**RE: Epiq Estate Lennox Head (Pacific Pines Estate) – Response to Submissions and Additional Information (MP 07\_0026 MOD 7)**

## **Attachment 1: Detailed BCD Comments – Epiq Estate Lennox Head – Response to Submissions (MP 07\_0026 MOD 7)**

The Biodiversity and Conservation Division (BCD) has reviewed the Response to Submissions (RtS) prepared by Newton Denny Chapelle dated 29 June 2020 for the te proposed modification (MOD 7), which involves Super Lot 5 in the Epiq Estate, Lennox Head residential development. The following comments are provided.

EPIQ ESTATE - LENNOX HEAD, NSW, 2478
SUPER LOT 5
BULK EARTHWORKS
PLAN

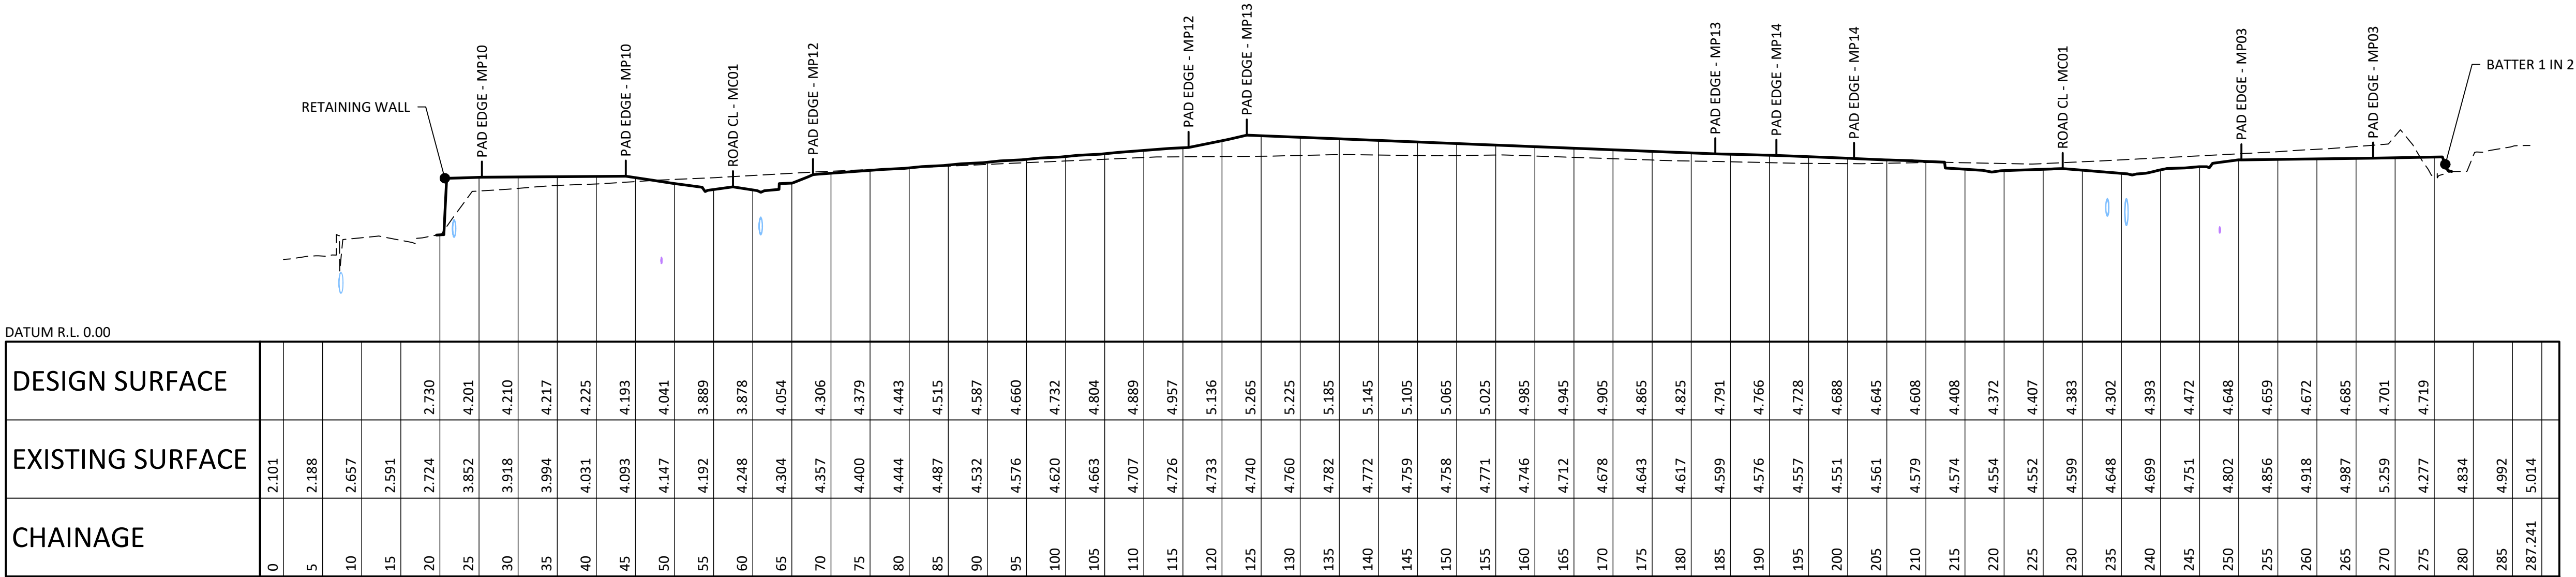
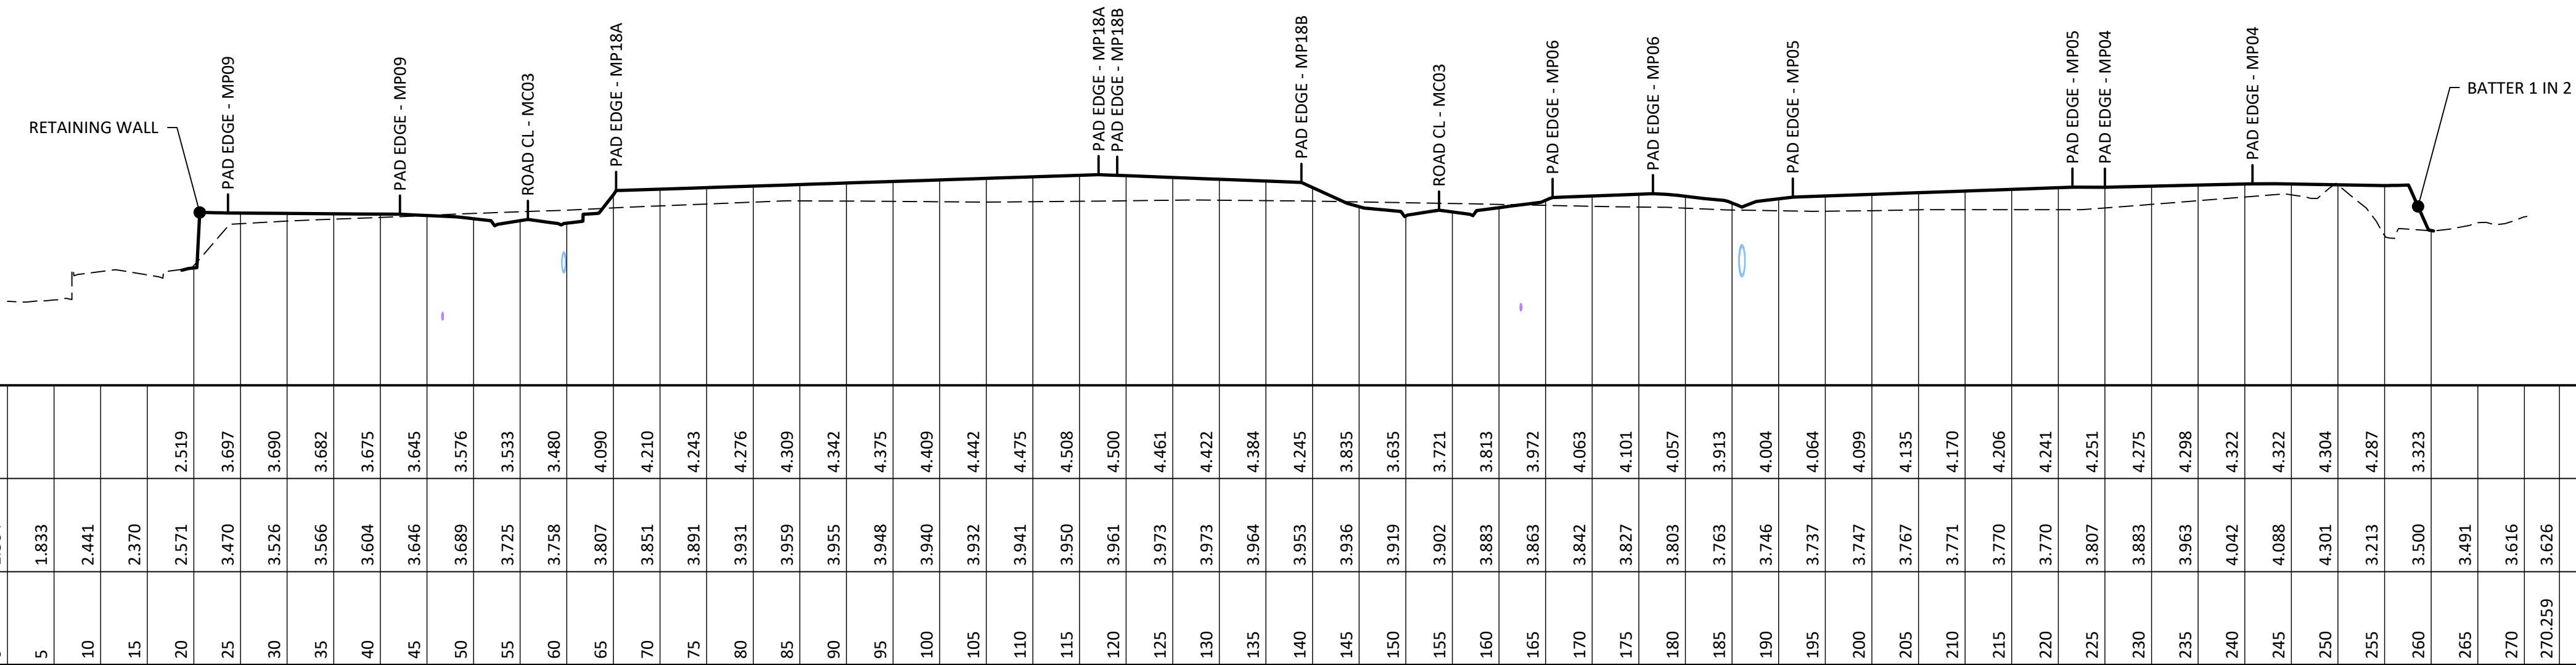
The RtS contains an amended Civil Works and Bulk Earthworks Plans. A drainage channel is now described that encroaches into the CMZ by 4m as shown in Drawing No. 14351-S5-DA-BE-12. The RtS states the additional drain is proposed to address the council's concerns regarding the drainage of low-lying areas of the CMZ and the location and configuration of this drain has been developed in consultation with the Ballina Shire Council. However, it appears the encroachment would not be consistent with the conditions of consent that no construction works are to be undertaken within the CMZ. We question whether this can be approved given the impact on the CMZ.

EPIQ ESTATE - LENNOX HEAD, NSW, 2478 SUPER LOT 5 CIVIL WORKS PLAN		
Reference No. 2014/351	DRAWING No. 14351-S5-DA-CI-01	REVISION B

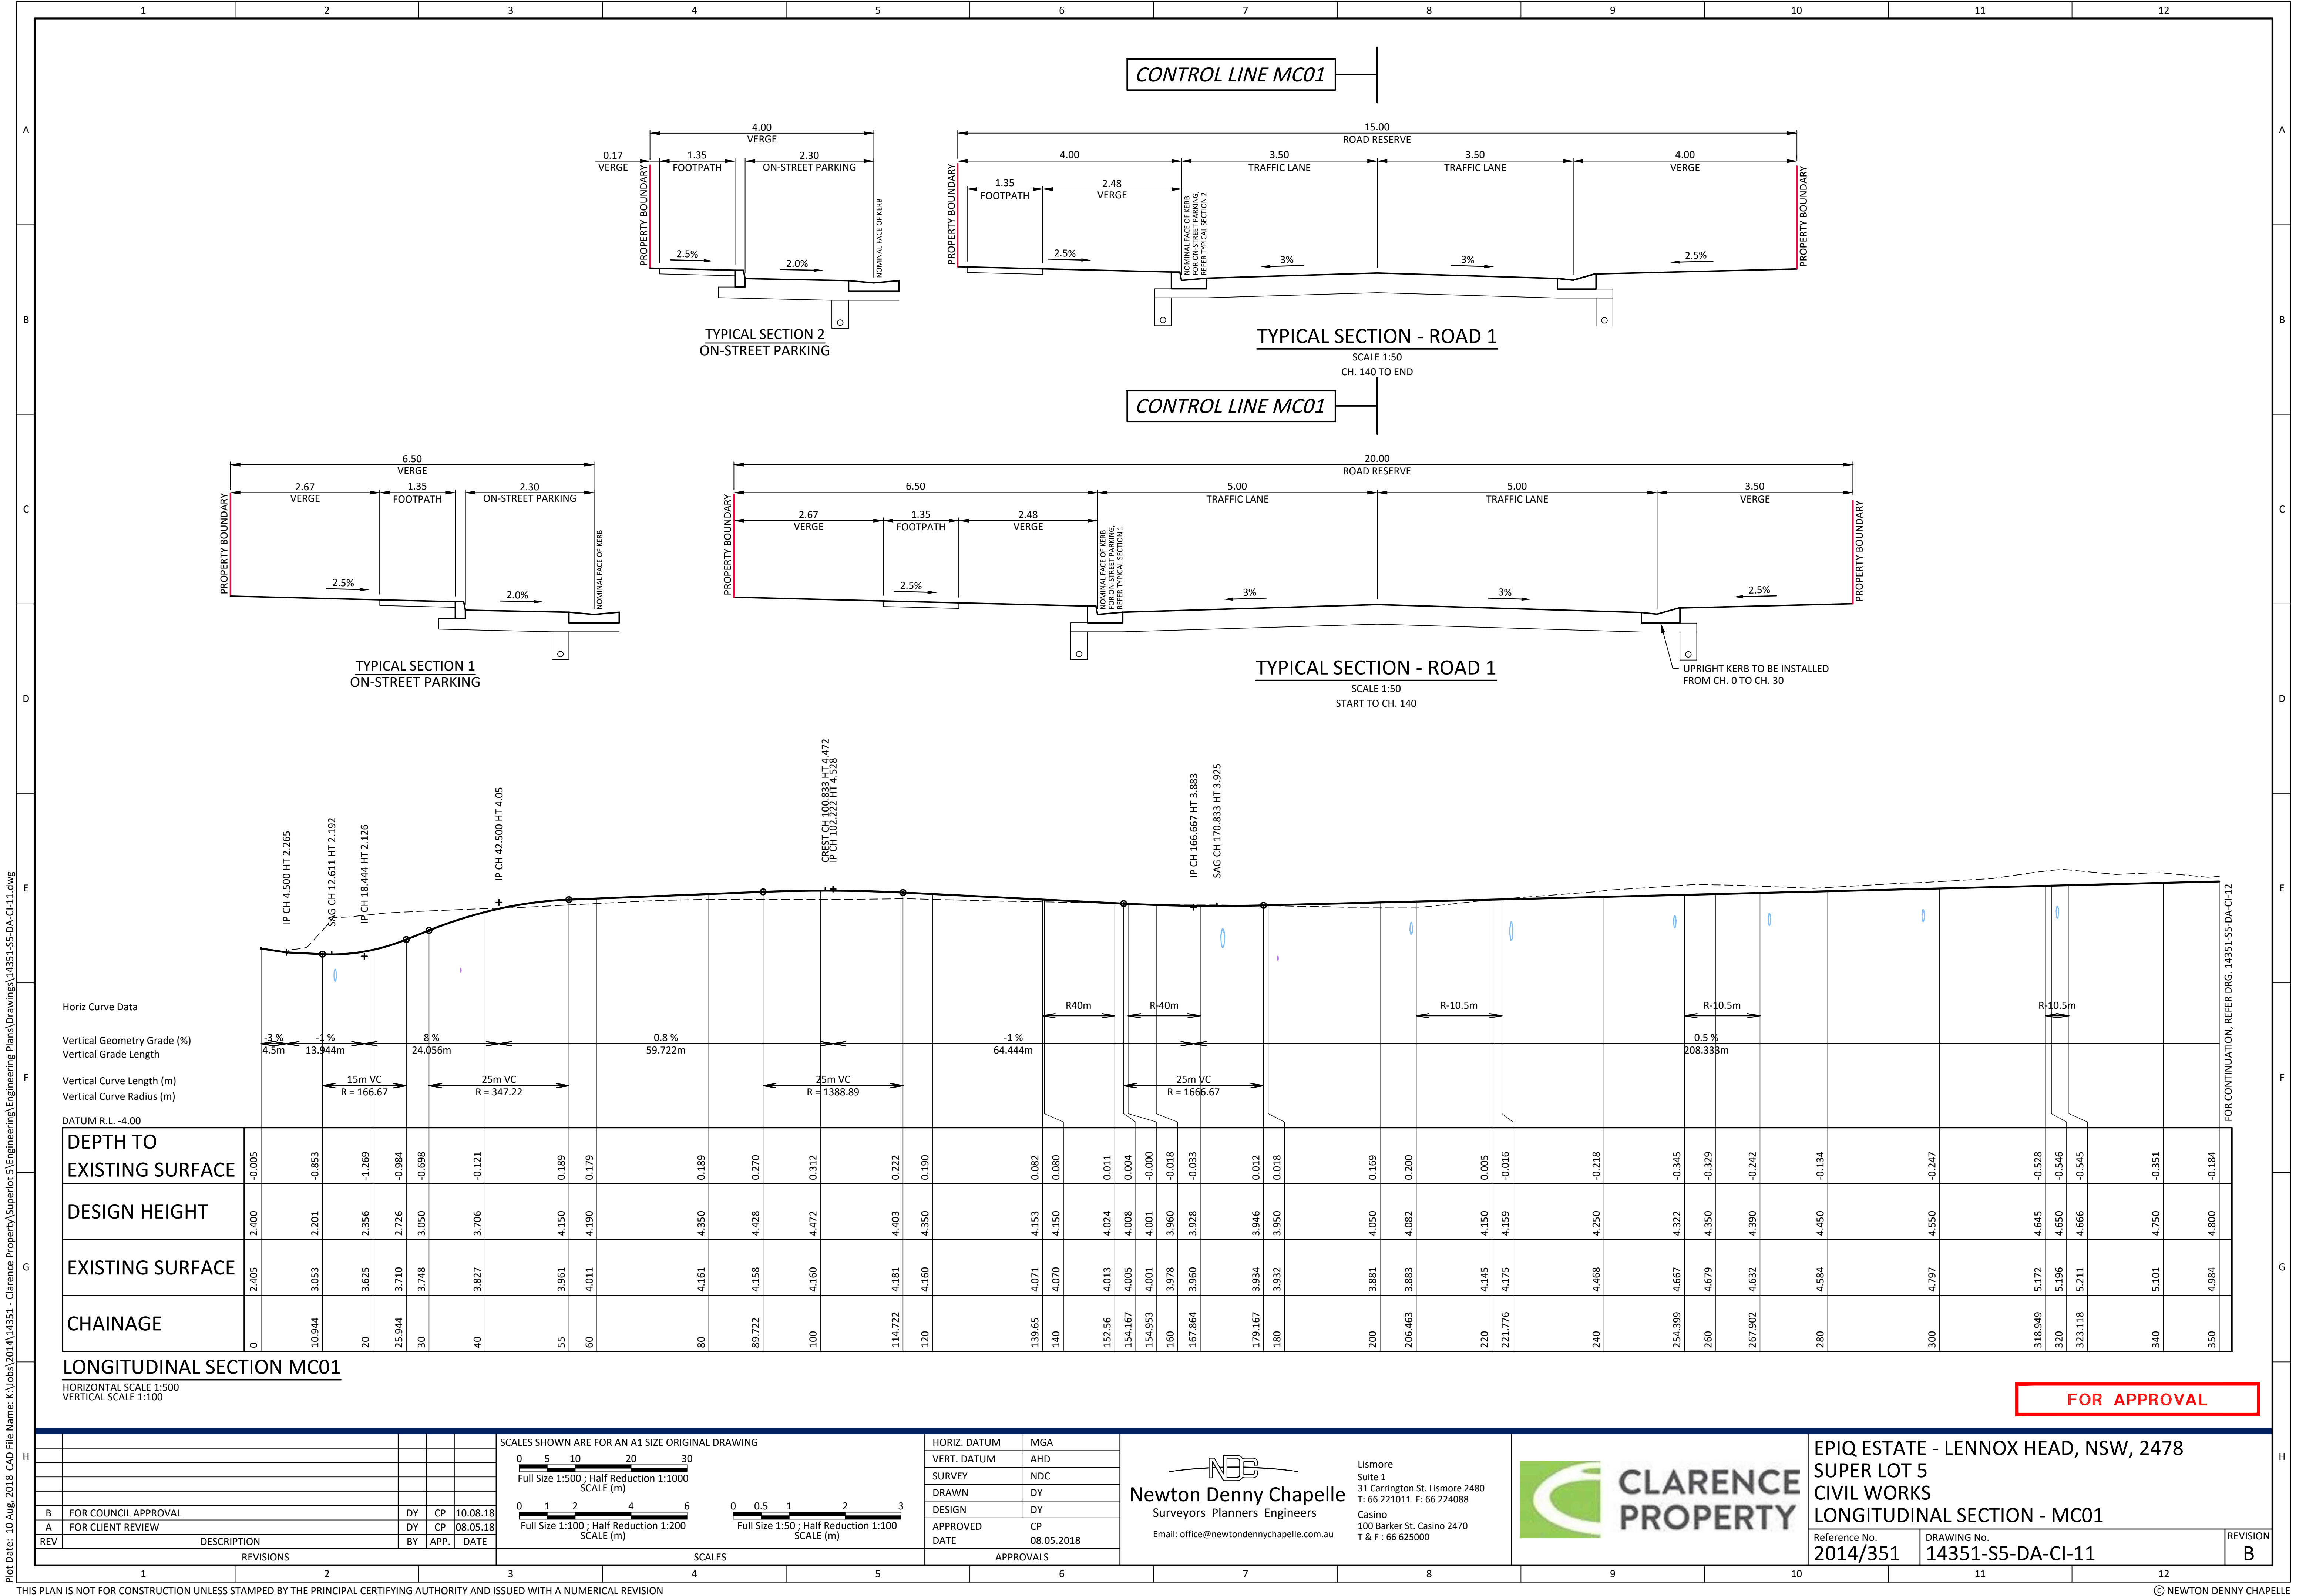
The concept engineering drawings show discharge points directly into the CMZ with no water quality treatment or gross pollutant traps. The BCD considers that stormwater treatment devices are required to treat the stormwater from Super Lot 5 before it enters the wetland. The proponent must demonstrate that pollutants and nutrients have been captured and treated so that they do not enter the CMZ and impact on the freshwater wetland and other vegetation communities.
